May 4, 2023

Project Name / File No.: Brodie / G22-0054
Applicant: JM1 Holdings, LLC
Project Description: 45 Lot PRD-Subdivision
Re: Response to Civil 1st Review Comments

This letter serves as the Applicant's formal response to the Civil 1st review comments received on December 29th, 2022 to our recent application materials submitted to the City of Marysville. To ensure that each of the comments have been responded to, we have incorporated each of the City's comments along with the Applicant's response to each below.

DRAWING NO.:	IL-01																																		
SHEET NO.:	1																																		
OF	3																																		
SHEETS

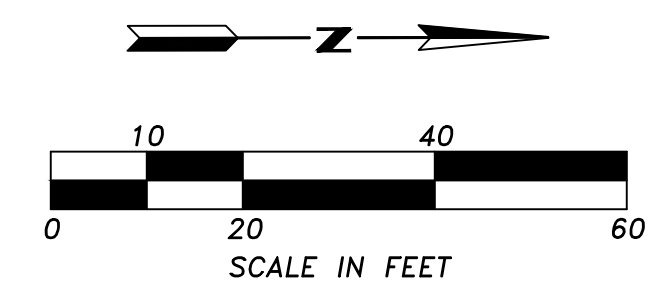
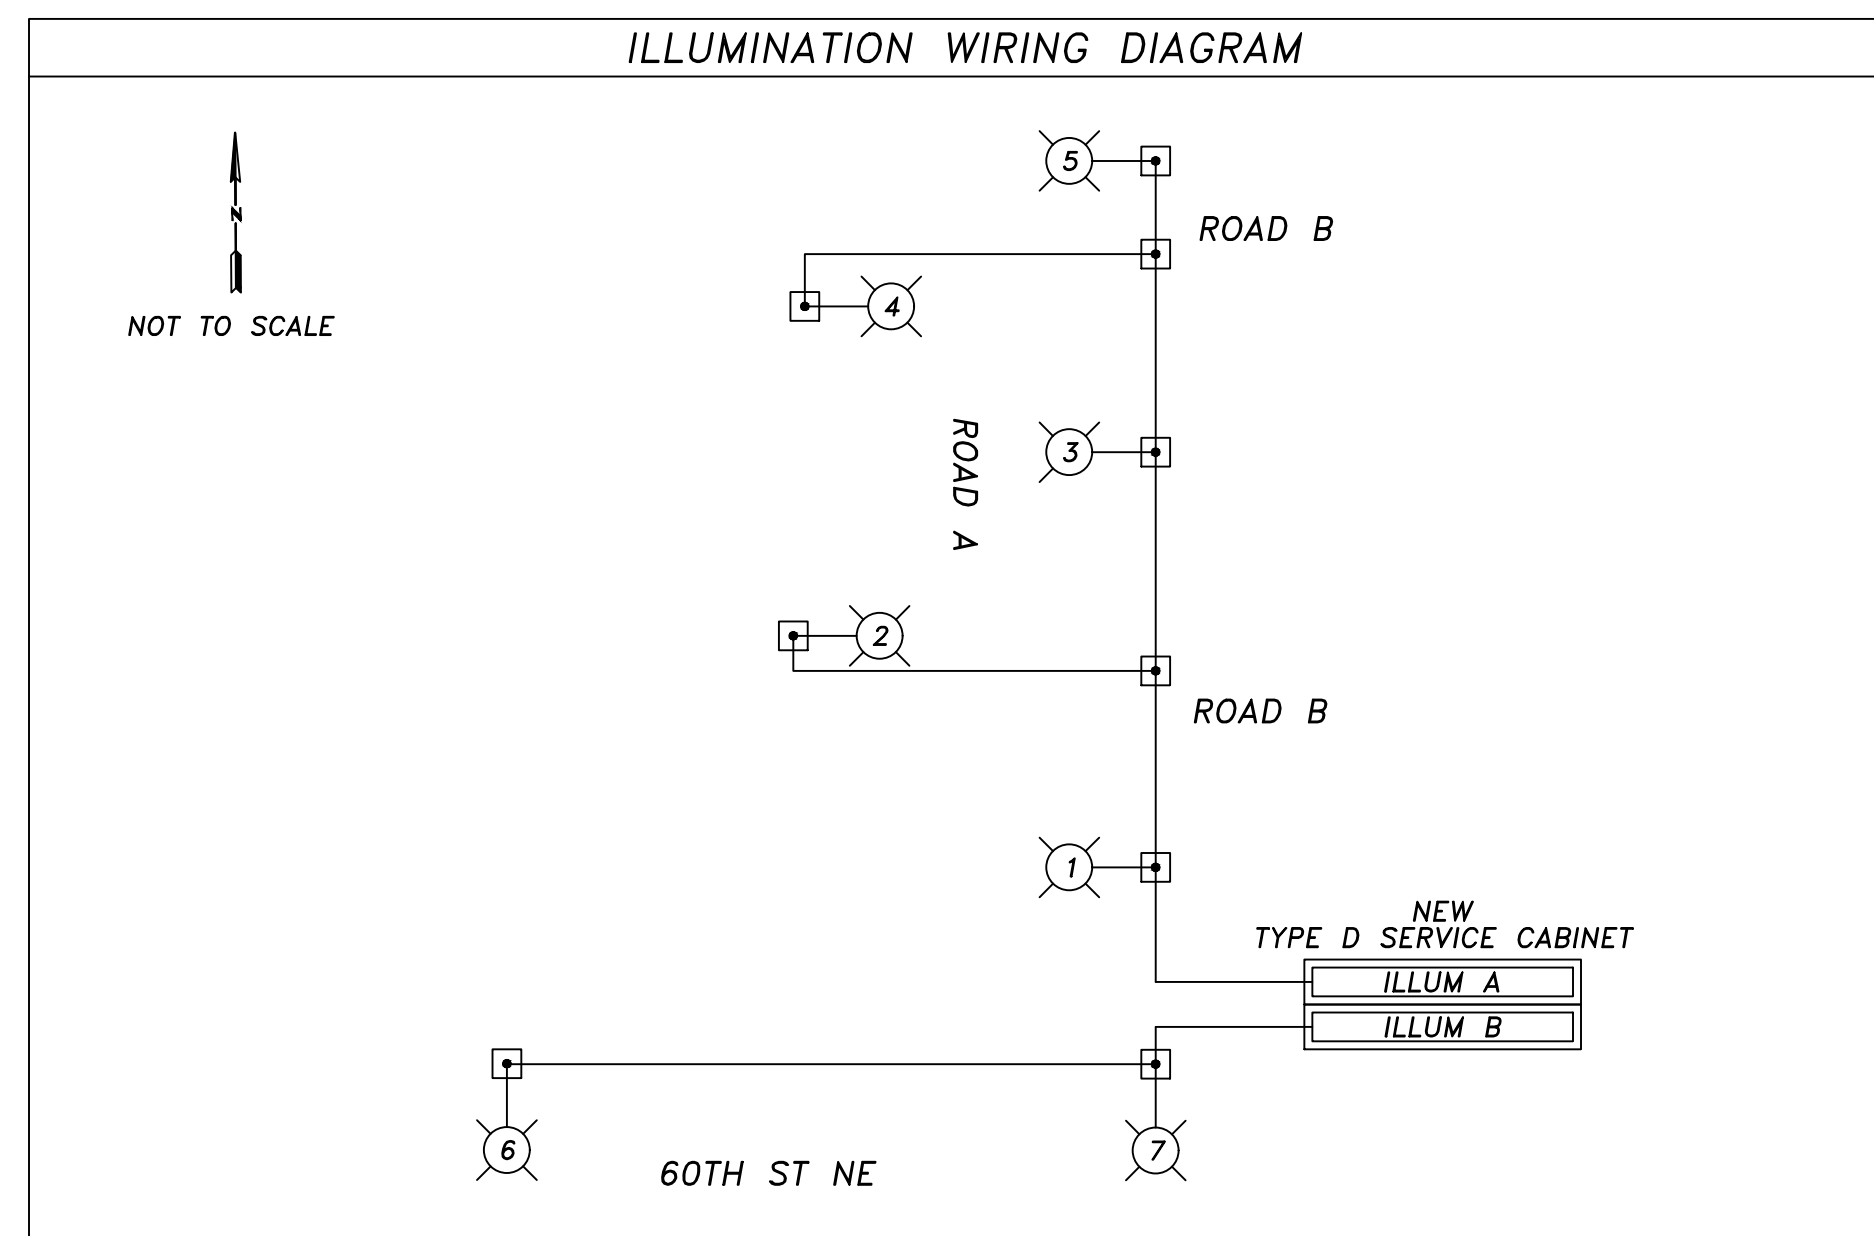
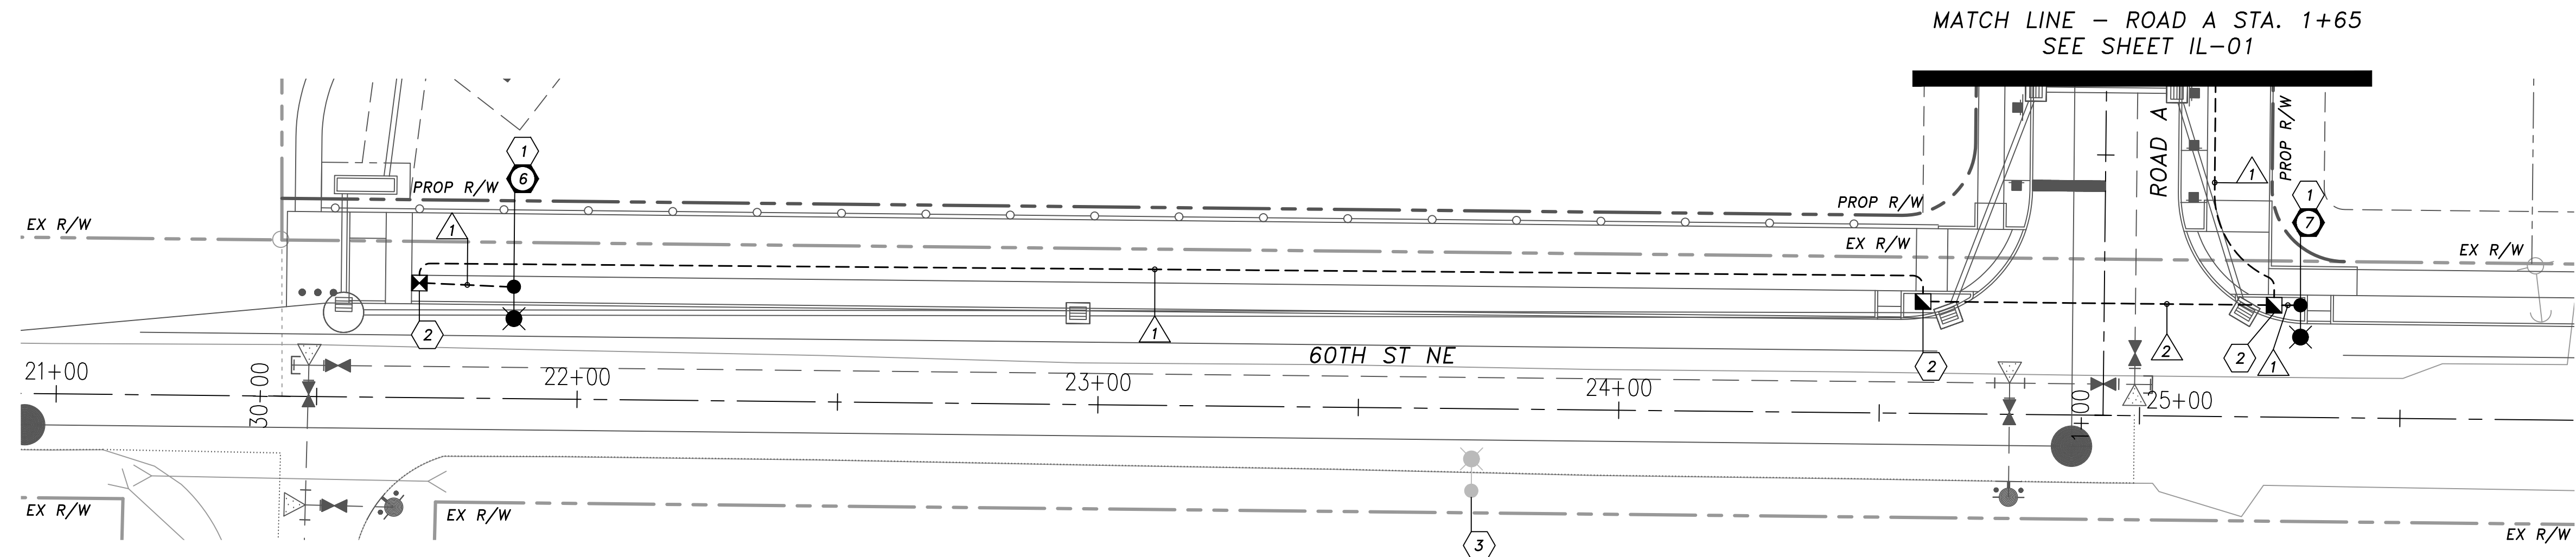
- 2) Per EDDS 3-506, street lighting will be required as part of civil construction plans.
 - a. Street Lighting upon 87th Ave NE from Soper Hill RD to 64th ST NE (SR 528) shall including City owned decorative street lighting to match installations within the vicinity.

- i. WSDOT Type D Service Cabinet shall be per City Special Provision with height of 46".
Applicant's Response: Noted. Lighting plans are being developed.

DRAWING NO.:	IL-02
SHEET NO.:	2
OF	3
SHEETS

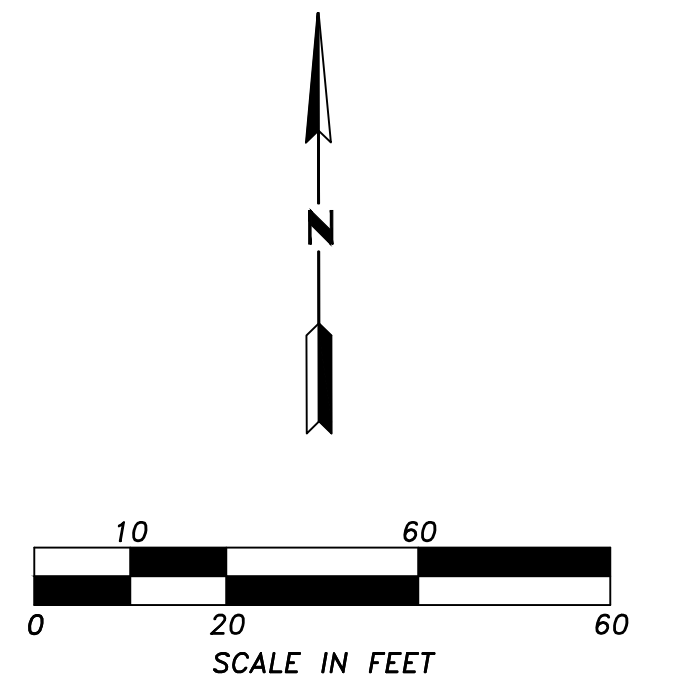
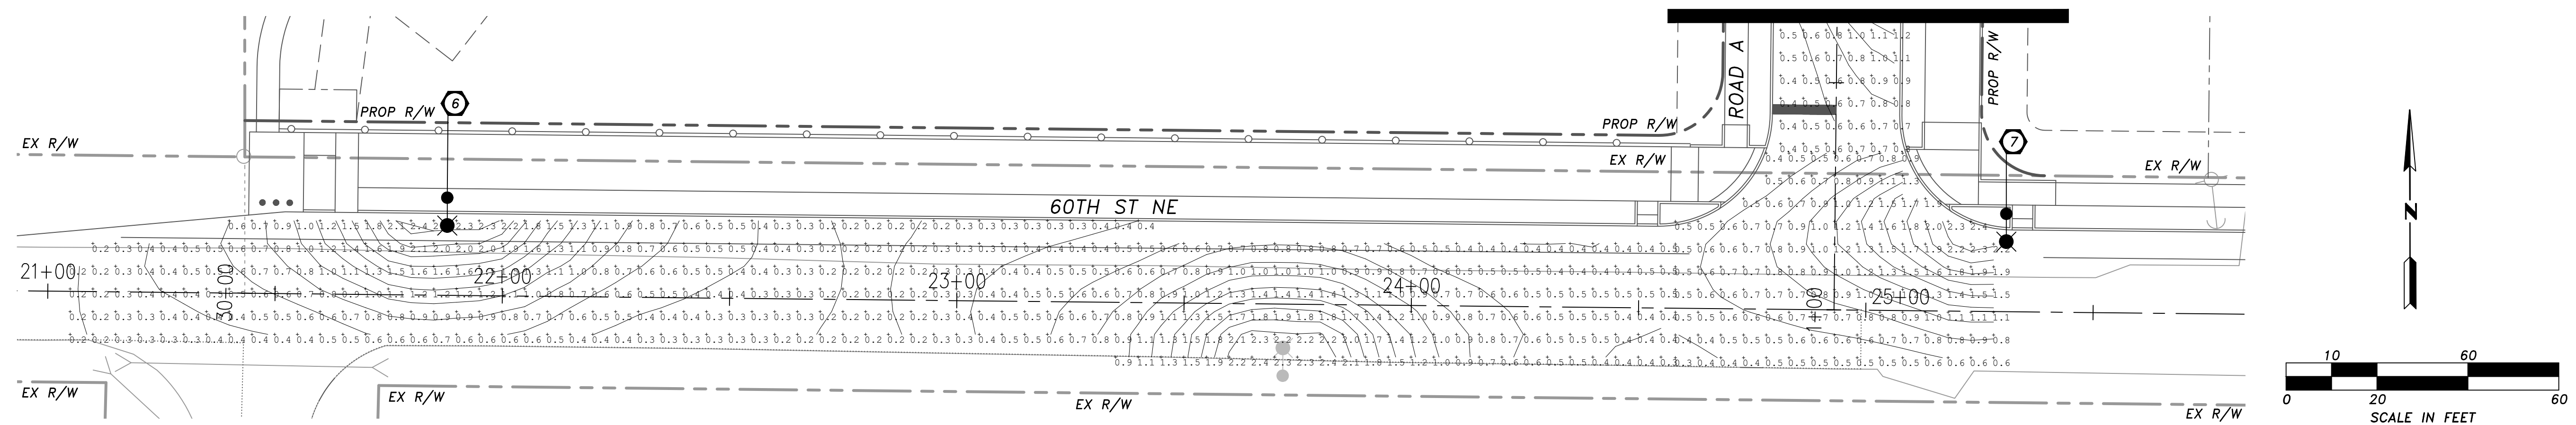
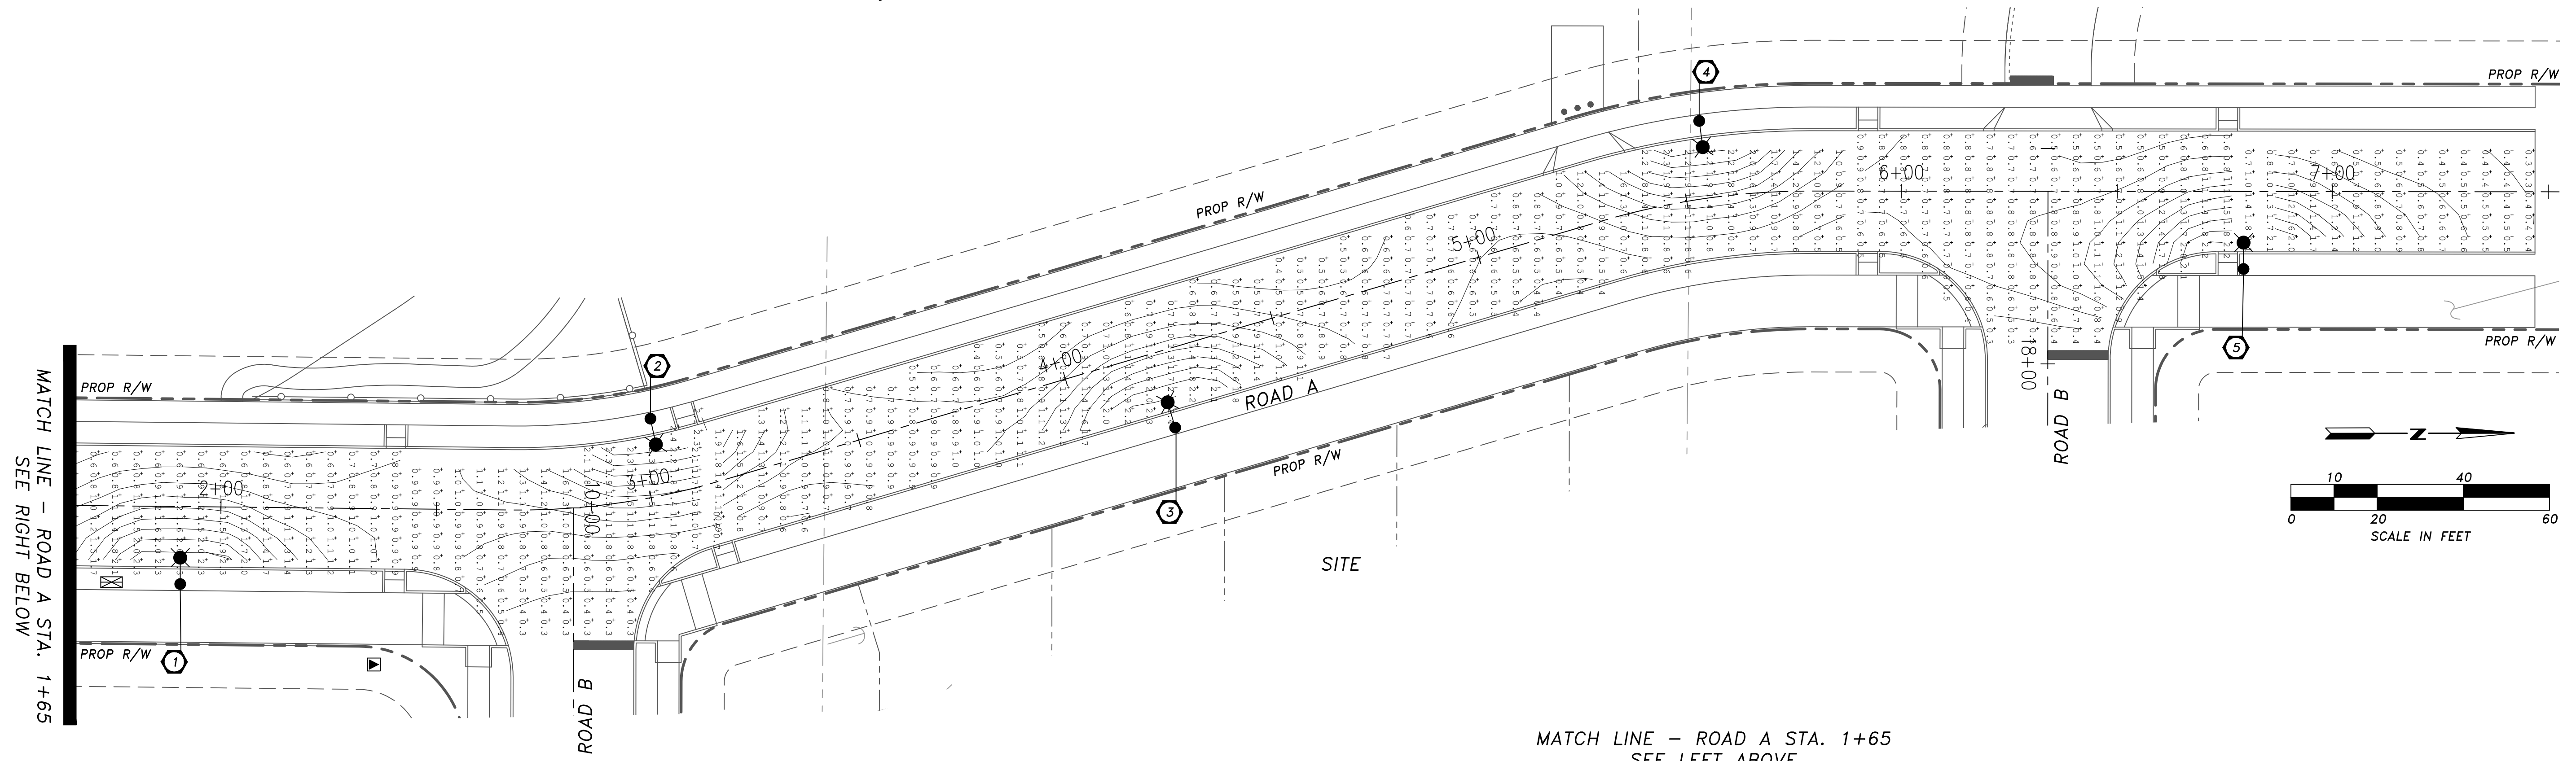
1. Approximate Street Light locations upon Road B:
 - a. STA 10+75
 - b. STA 12+75
 - c. STA 14+75
 - d. STA 16+75

Applicant's Response: Street lights have been placed along Road B at the locations as requested.
